Consultation Response from: KC Environmental Health (Pollution & Noise Control)
2025/90104 - 1A Lord Street, Huddersfield, HD1 1QA
Alterations to convert ground floor unit to three residential apartments and external works to shopfront (within a Conservation Area)
Responding Date:
13 March 2025

Responding Ref:
WK202506210

Rev.	Description	Date.
Client: London Properties 1 Lord Street, Huddersfield, HD1 1QA		
Project: Proposed Internal Alterations - Apartments		
Title: Proposed Floor Plans & Elevations		
Status: Planning		
Scale: 1:100 @ A1	Date: Jul 2024	
Dwg No: 24743_P_105	Revision: -	Drawn by: JTS Checked by: JAB

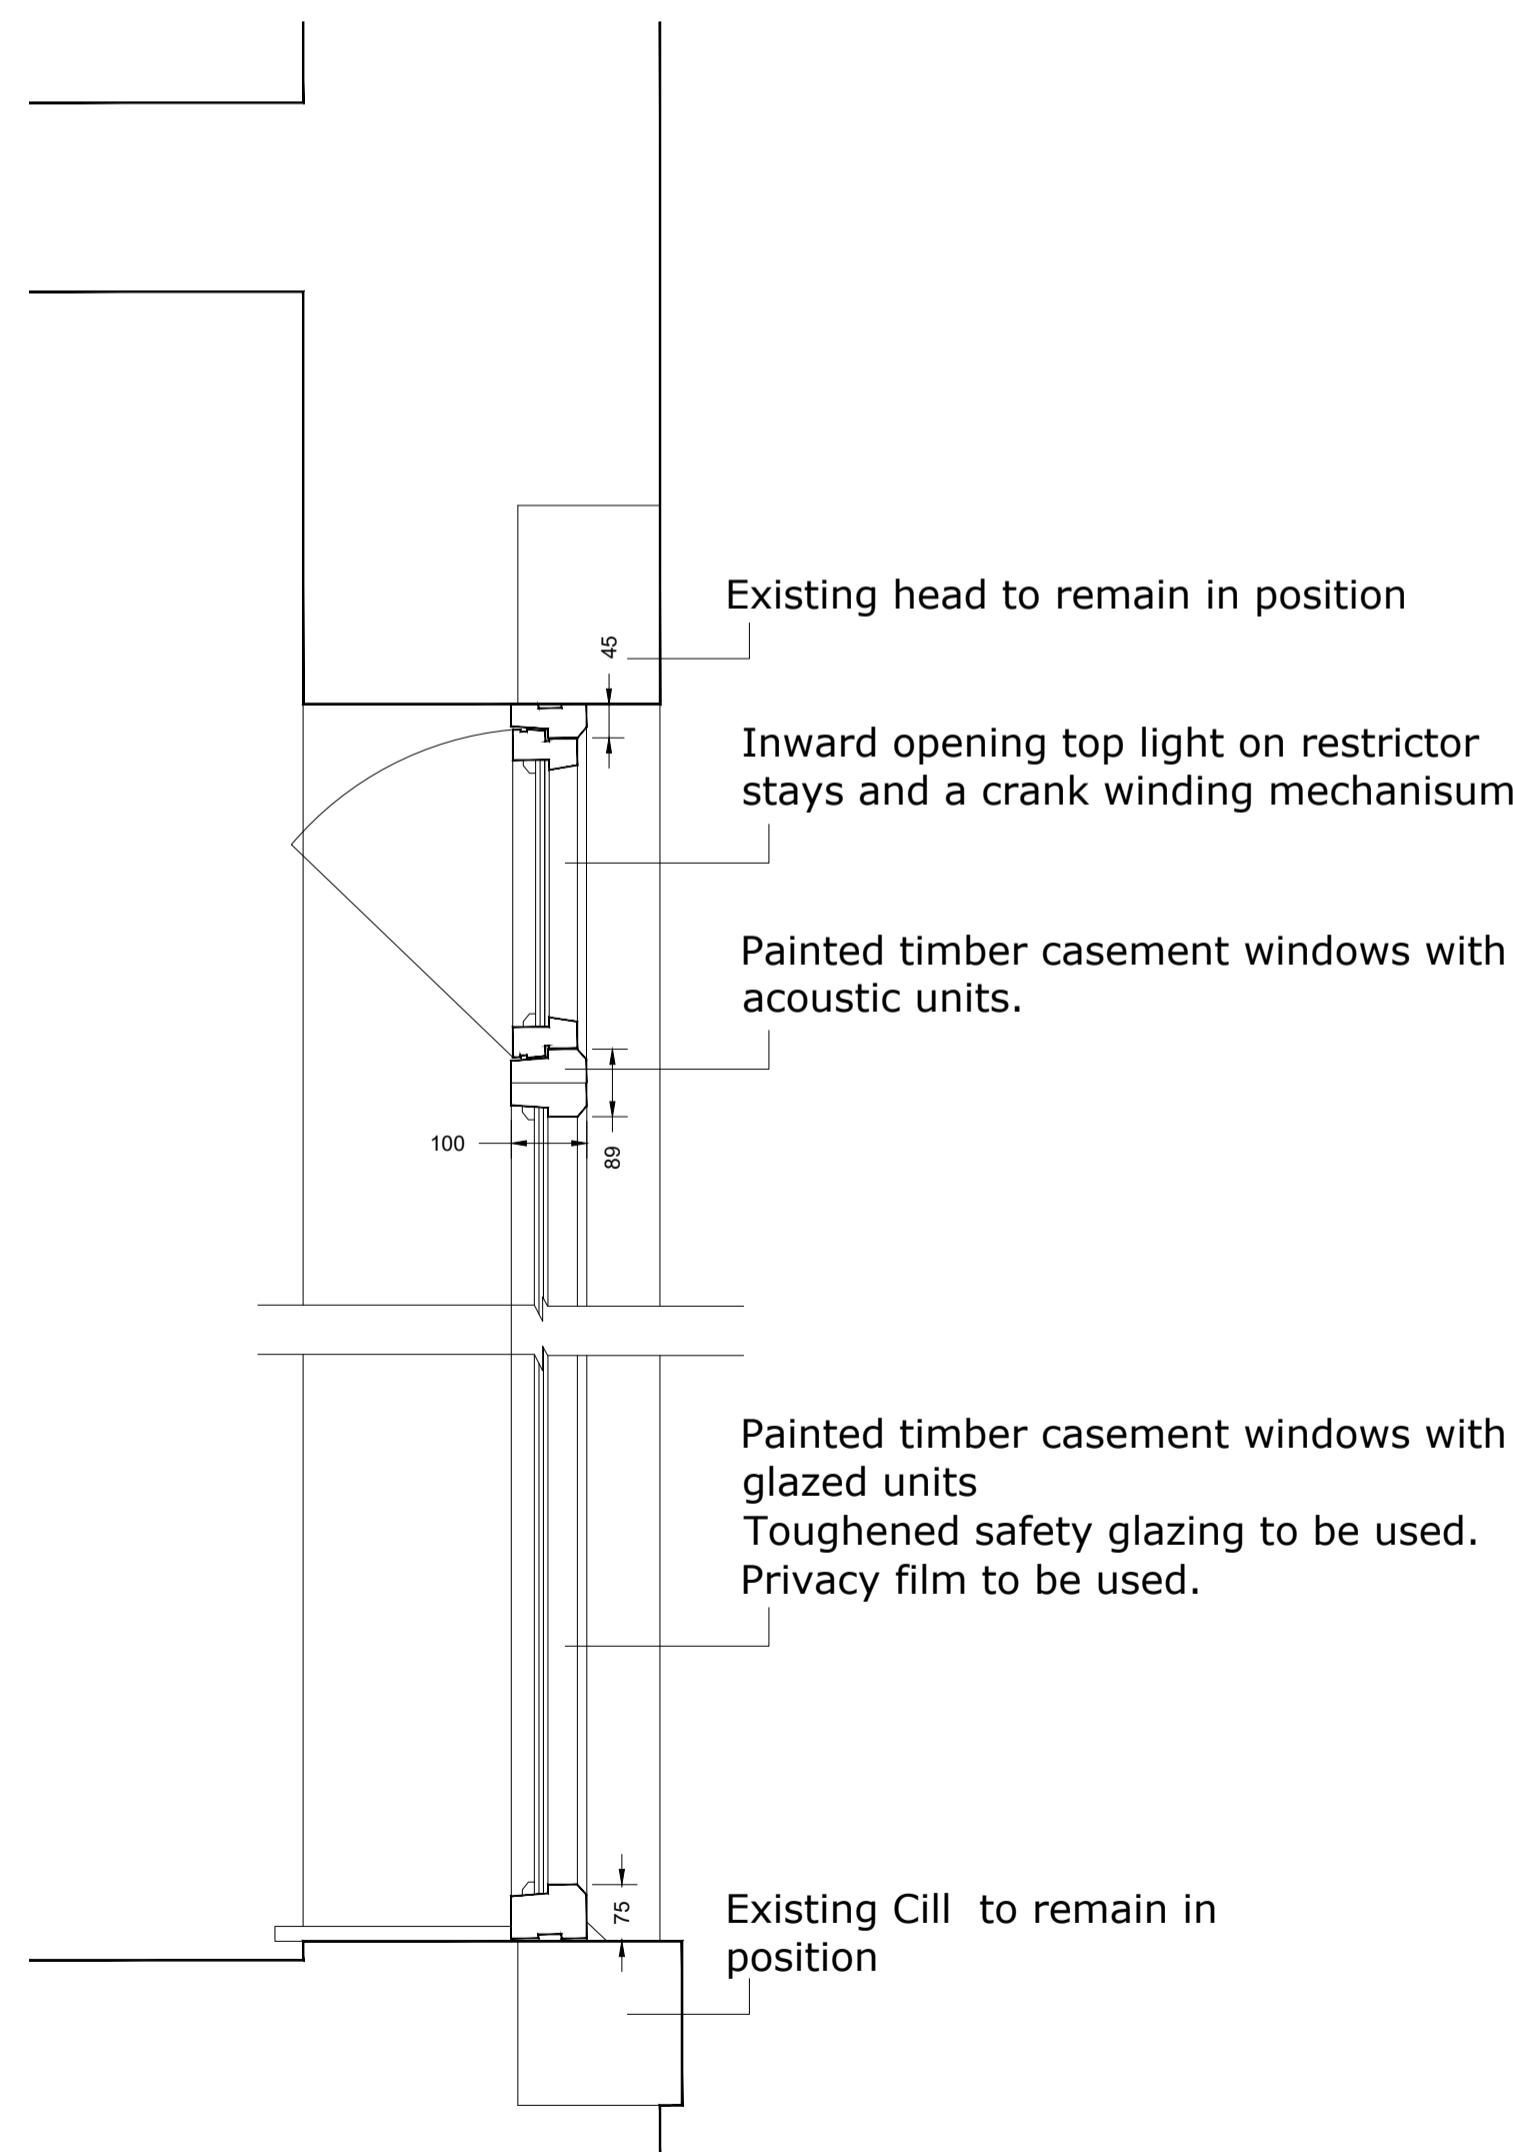
The proposal sits in the town centre area and we have concerns about noise affecting the amenity of the occupiers. There are licensed premises in the immediate area along with commercial premises and a road junction so a condition is recommended for the submission of a noise assessment to consider all sources of noise. There is a commercial property next door and we have similar concerns about the transmission of noise. A higher level of sound insulation is required where commercial and residential uses share a party wall and a condition is therefore recommended to ensure the development meets with this requirement.

The site is within an existing Air Quality Management Area and near a road of concern. A condition is recommended for an air quality screening assessment to be submitted, the findings of which will determine if a full air quality assessment will be required.
